PHILIP GOACHER ASSOCIATES

Our Ref: PSG/sh/13177/001

Re: ~~135~~ & 135A WICK STREET, LITTLEHAMPTON

Drawing Title
Extension Scheme
Proposed Elevations

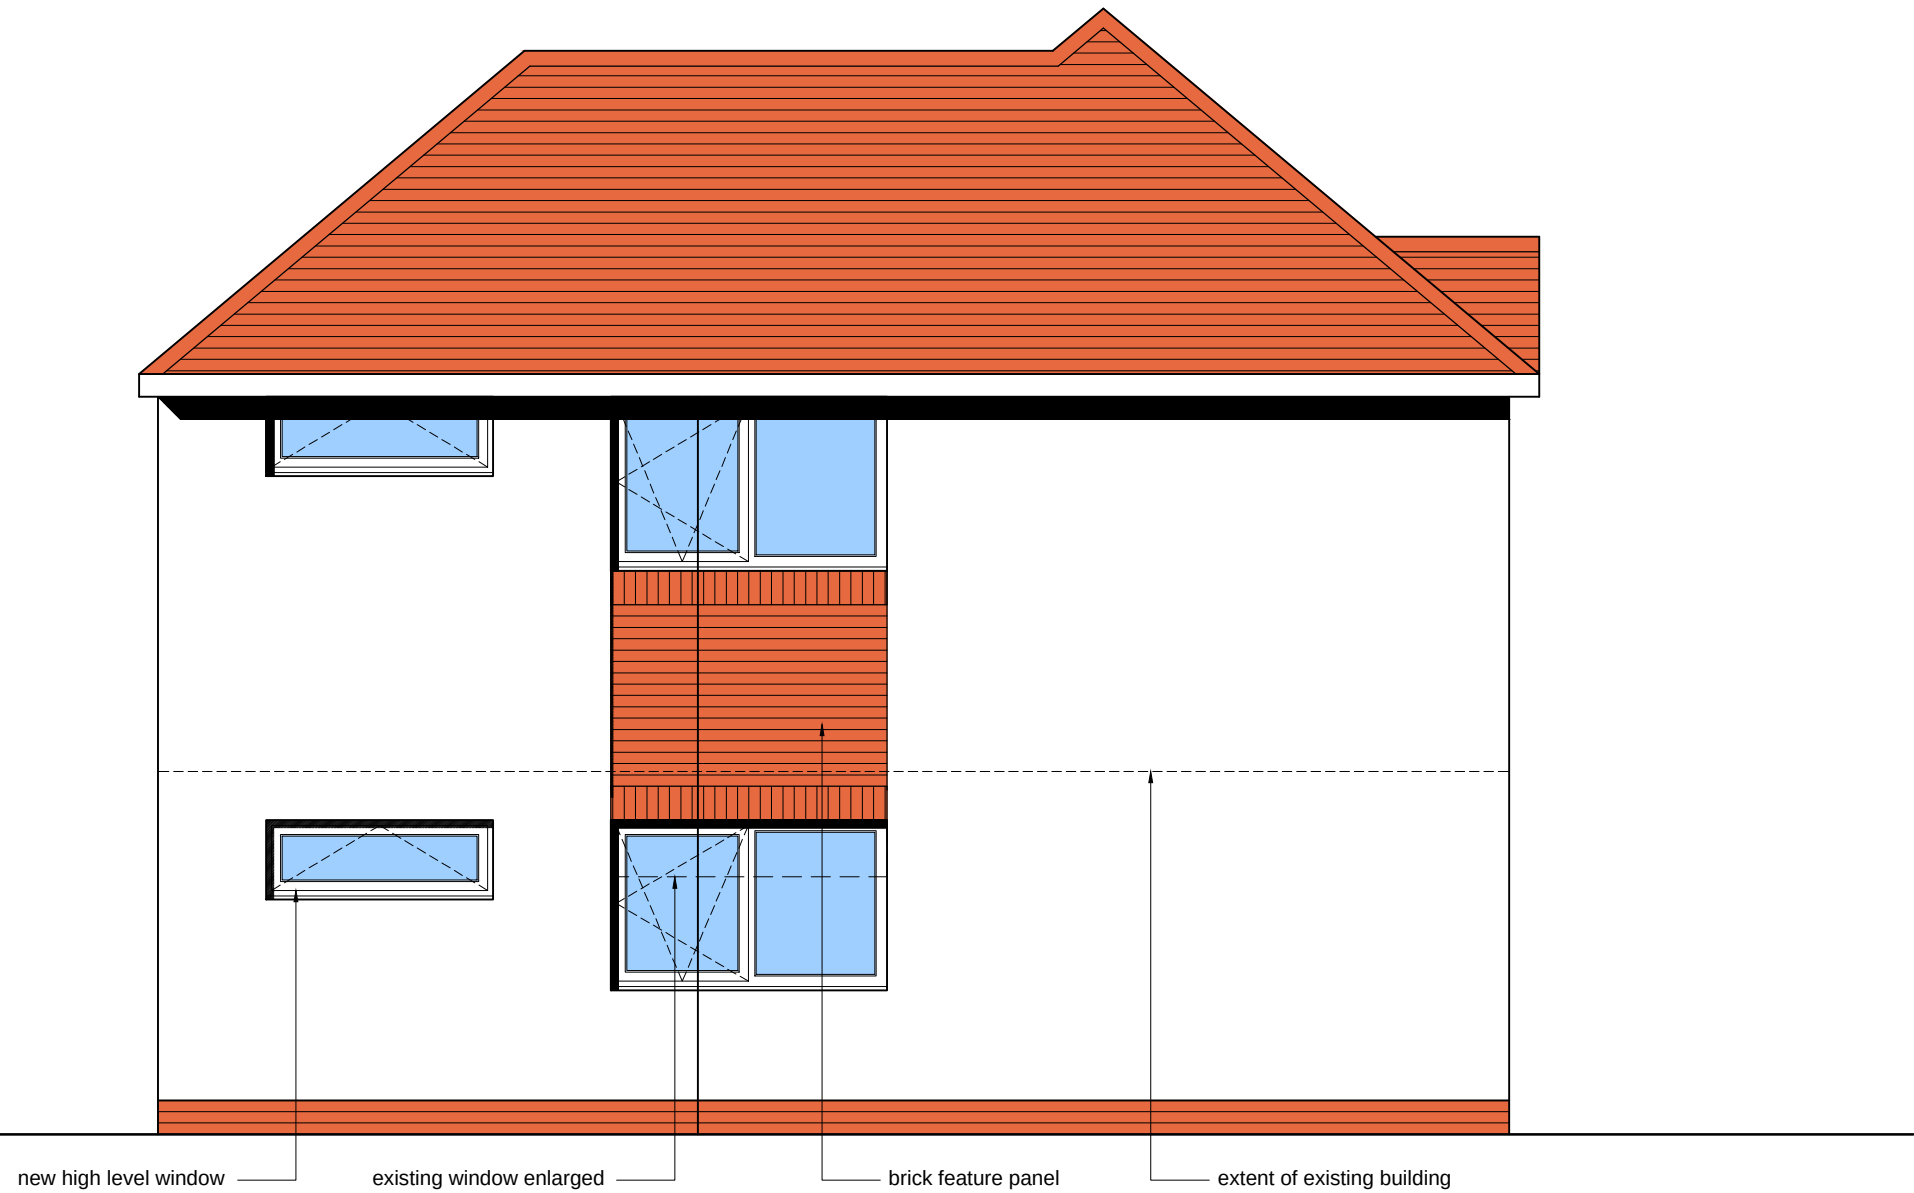
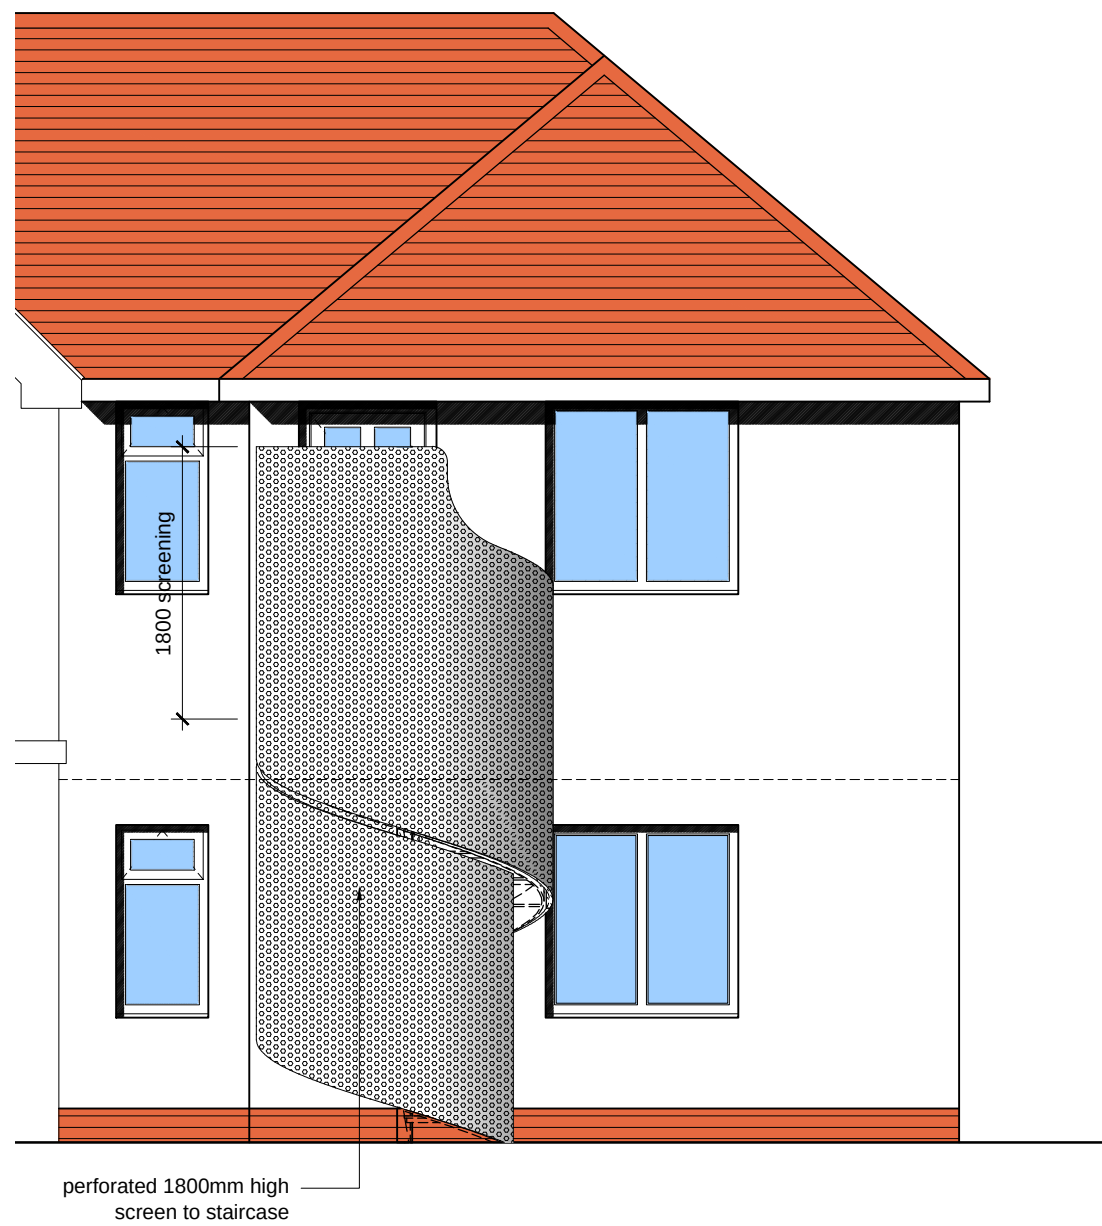
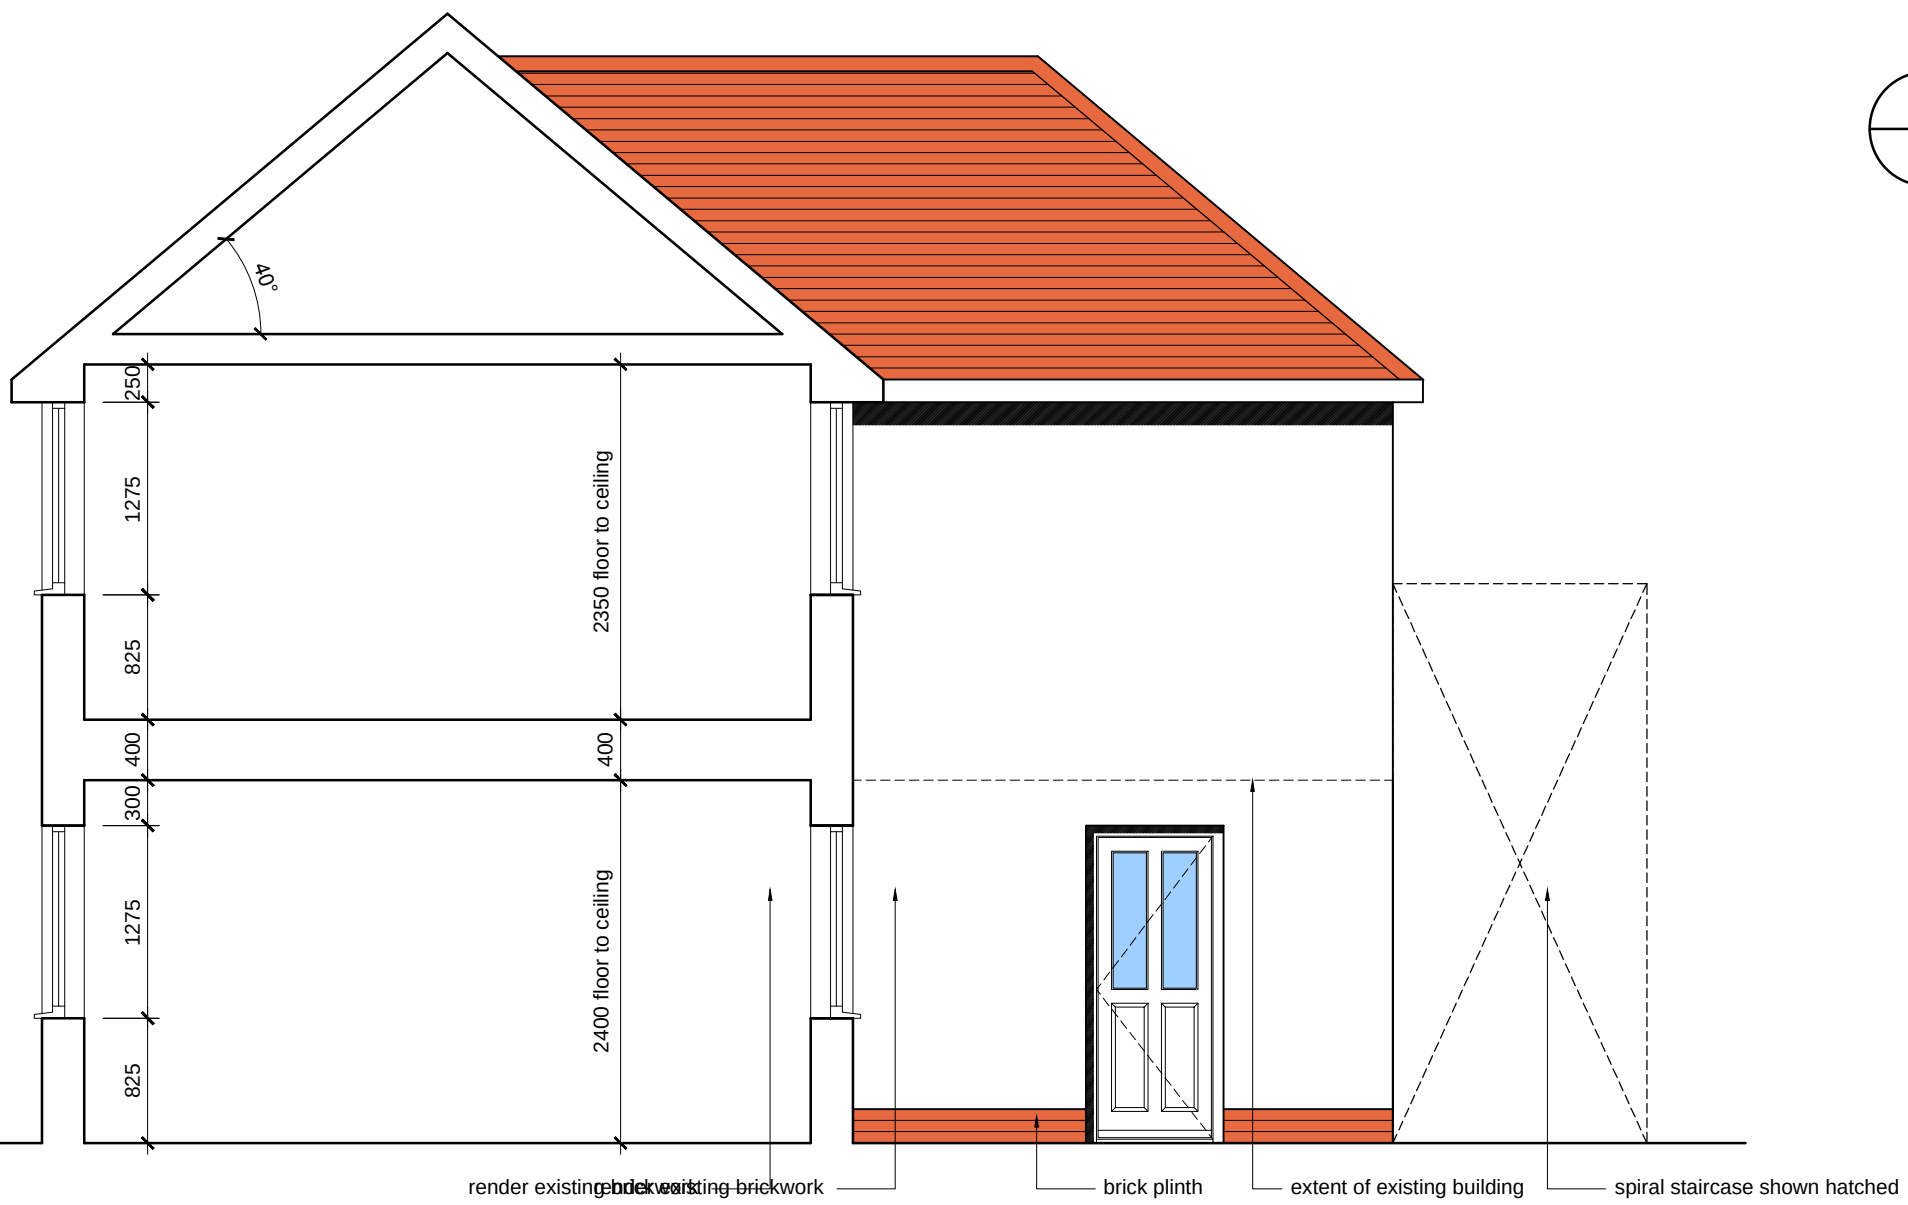
- 1.6 With regard to the existing rear elevation and proposed first floor rear elevation, it is noted that large window openings have been shown and a fairly small return pier at the south-west corner of the building at both levels will be created. This will require a steel frame to be provided around the windows at each level in order to maintain stability. Alternatively, a cheaper option will be to increase the pier length to perhaps 600mm or 750mm projecting from the south wall. This will avoid the need for the steel frame and other potential complications and will keep the structural form as simple as possible.
